# Preferred Project Report

Application No.MP09-0039 for  
Mixed-Use Retail/Commercial/  
Community/Entertainment/  
Residential Complex

157 Redfern Street  
REDFERN

October 2009

Proposed - 21 June 1200
Scale 1:2000

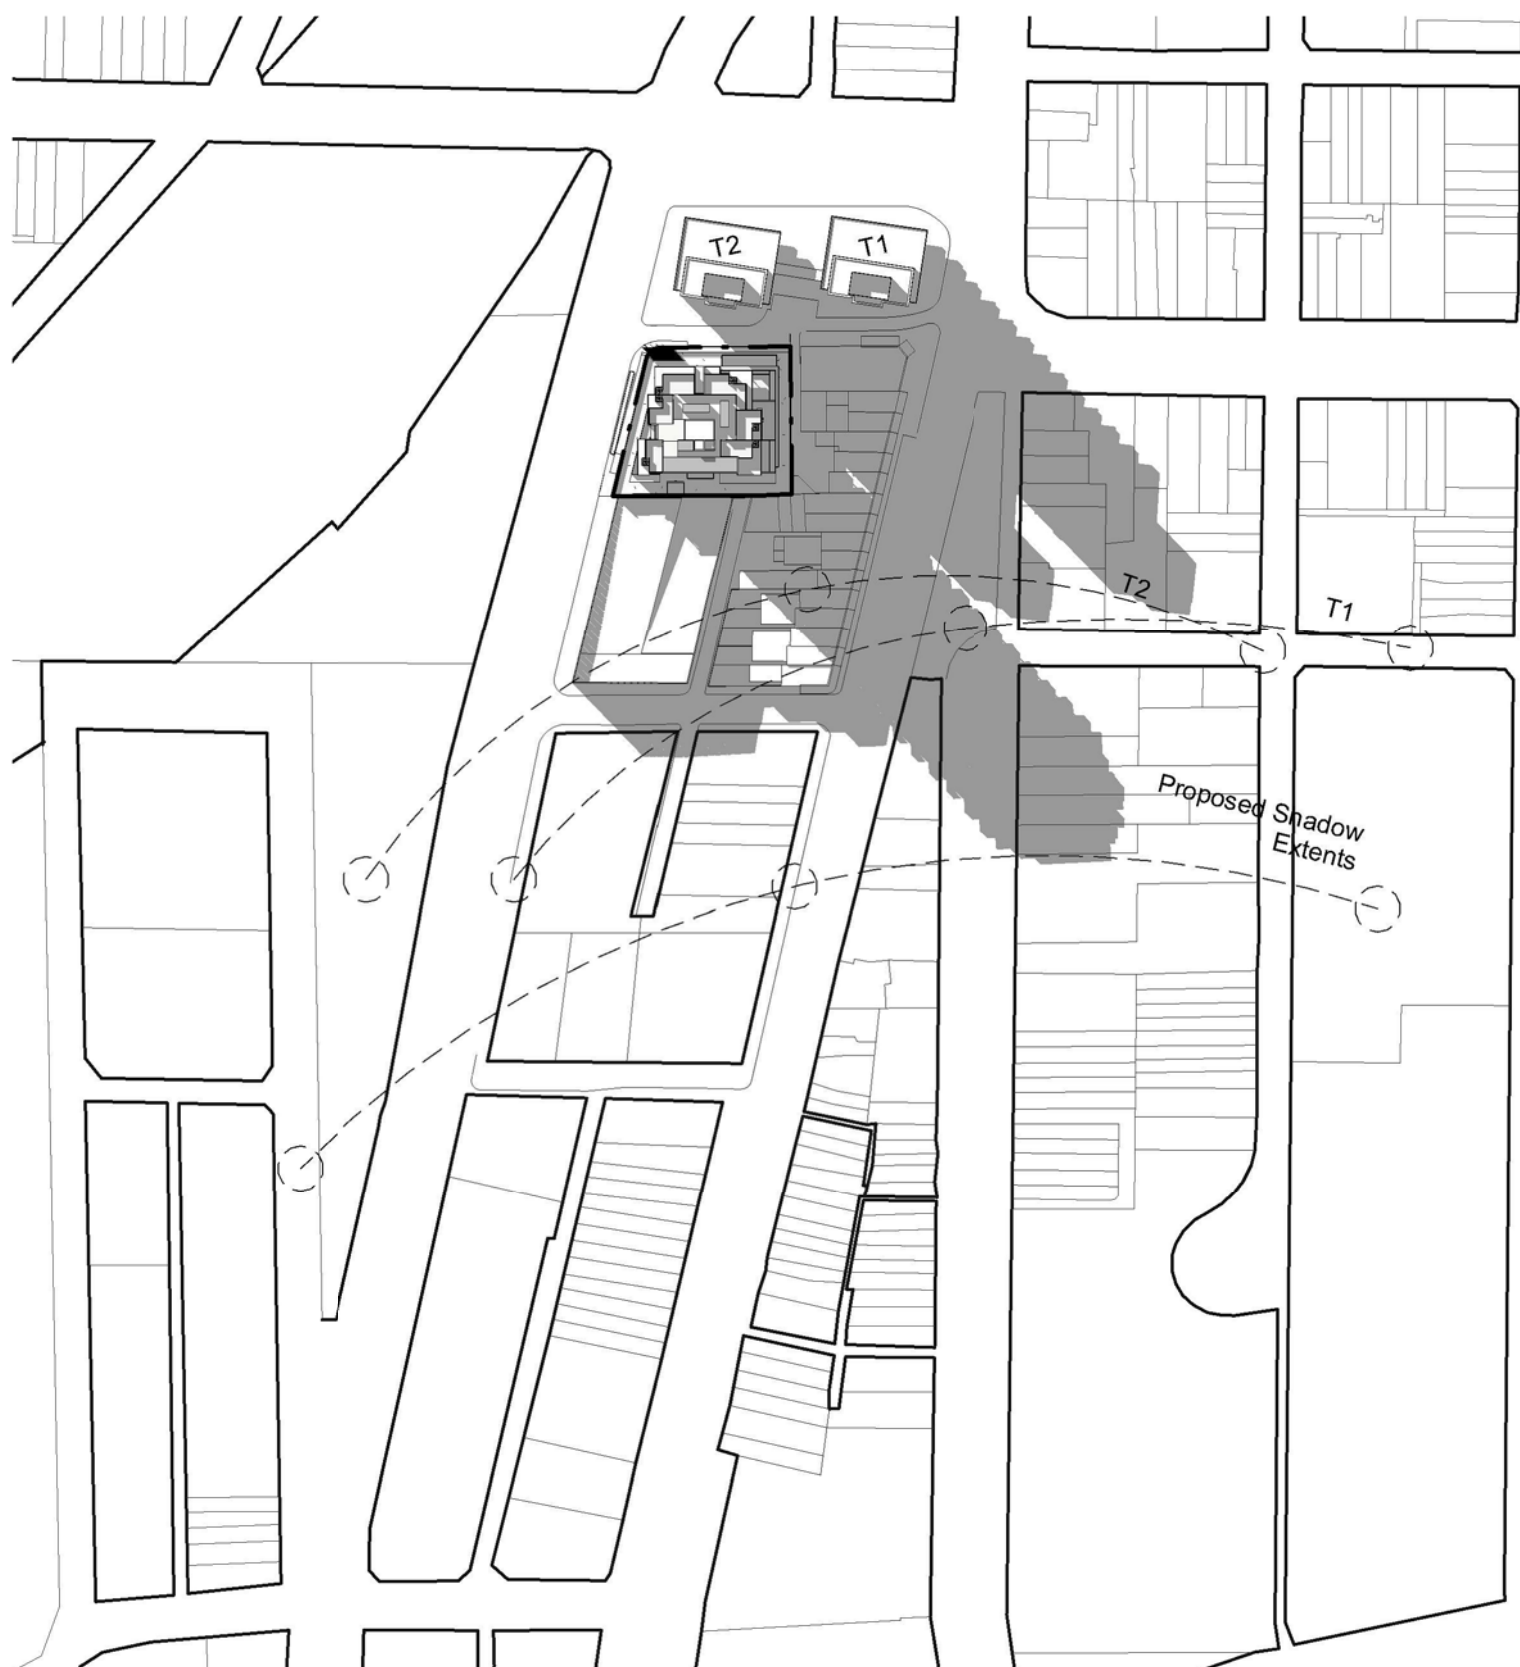
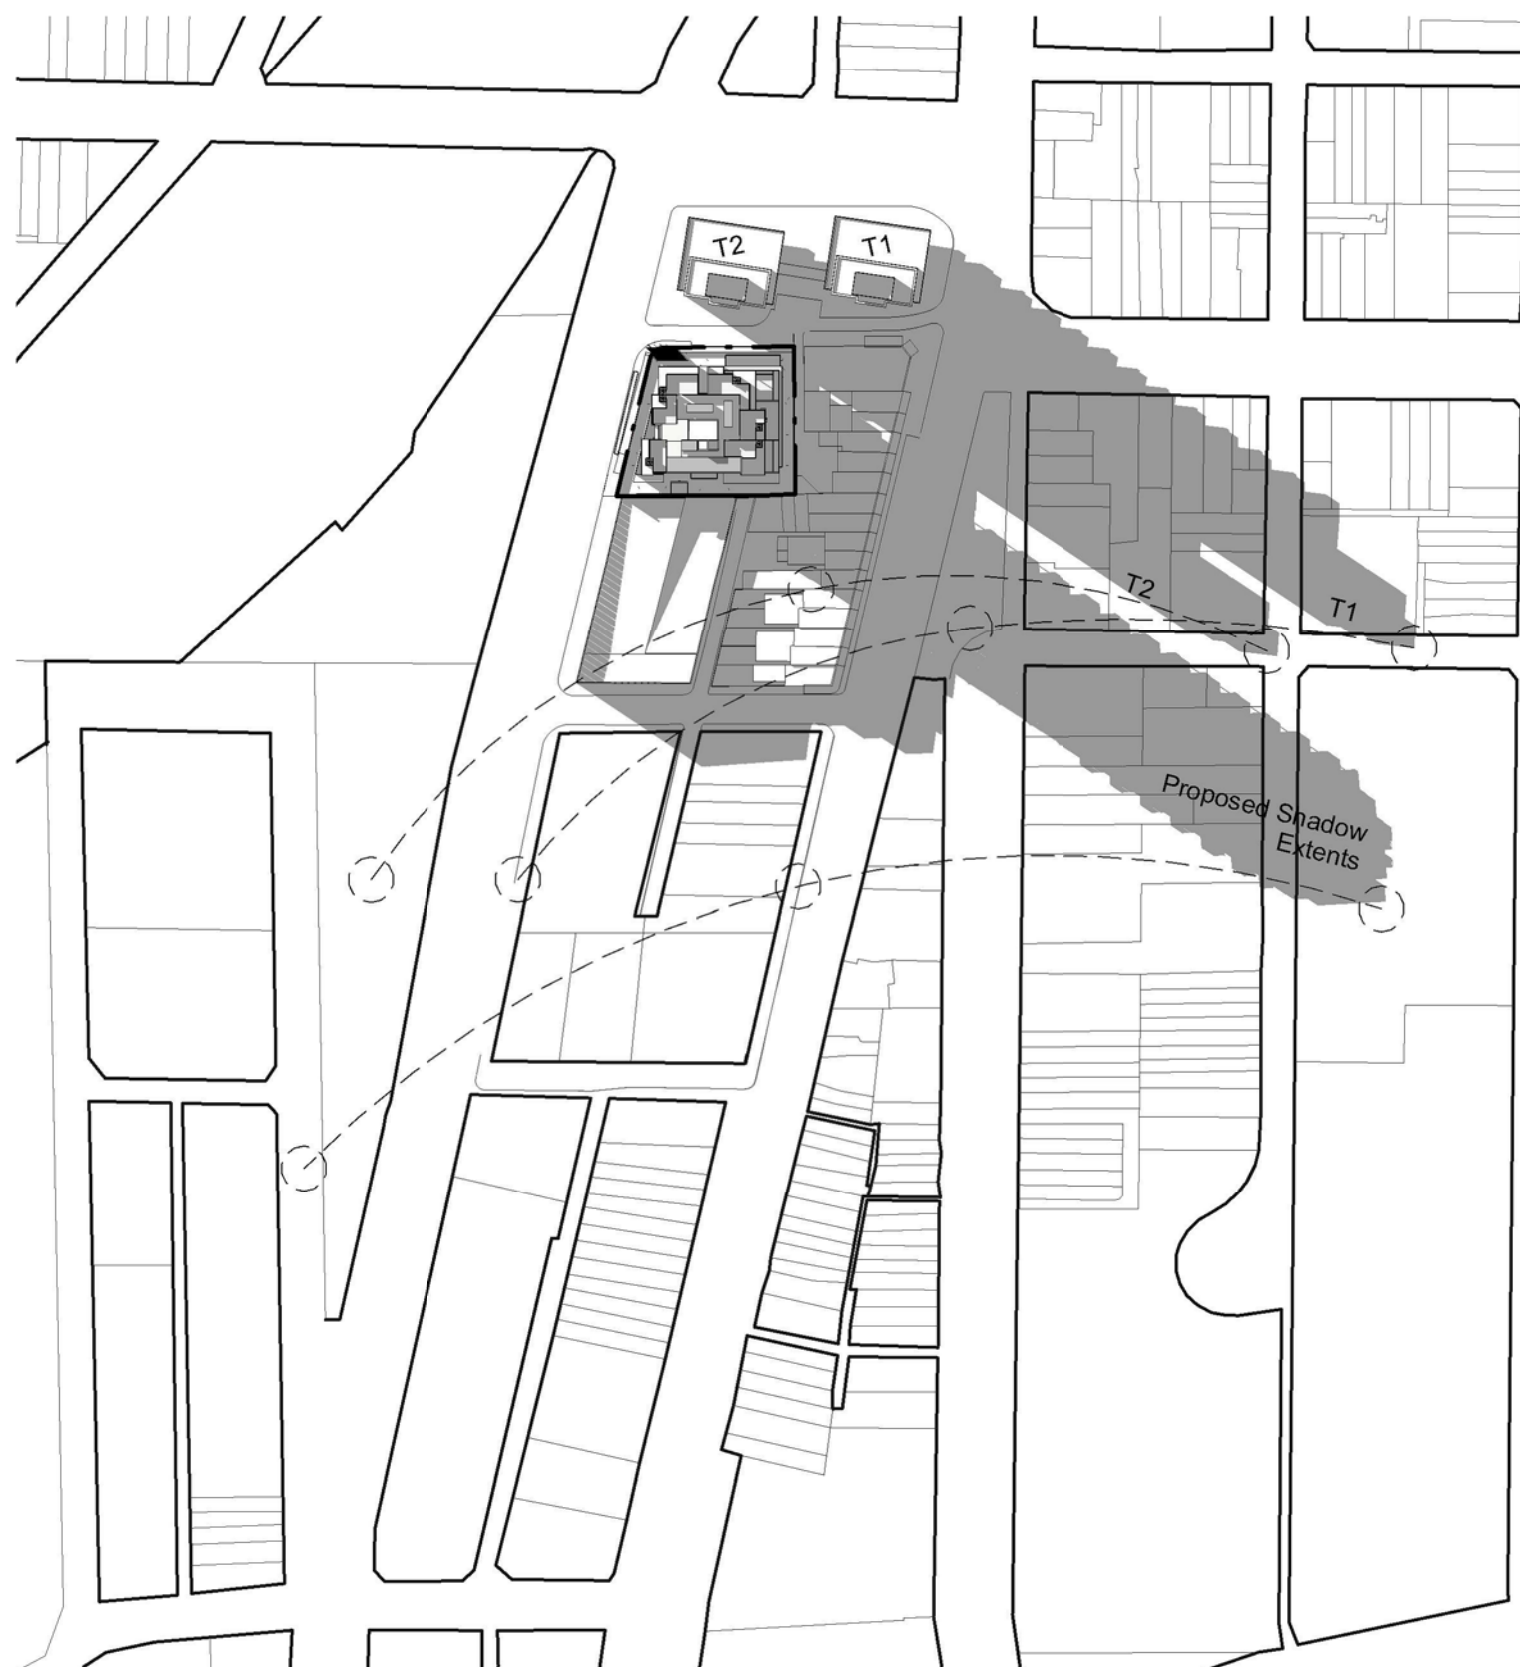
The number of the community submissions raised issues relating to overshadowing, particularly of 13 Margaret Street, while the RWA requested additional shadow diagrams to be submitted for 10am and 2pm.

Shadow diagrams were contained on the plans that were submitted with the application and the additional shadow diagrams requested by the RWA have been included in the preferred project plans contained in **Appendix 1**.

The proposal will marginally overshadow 13 Margaret Street between 9.30am and 10.30am at the winter solstice.

The re-positioning of the building as shown on the preferred project plans contained in **Appendix 1** will, to a minor extent, ameliorate shadows cast to the south and south-east.
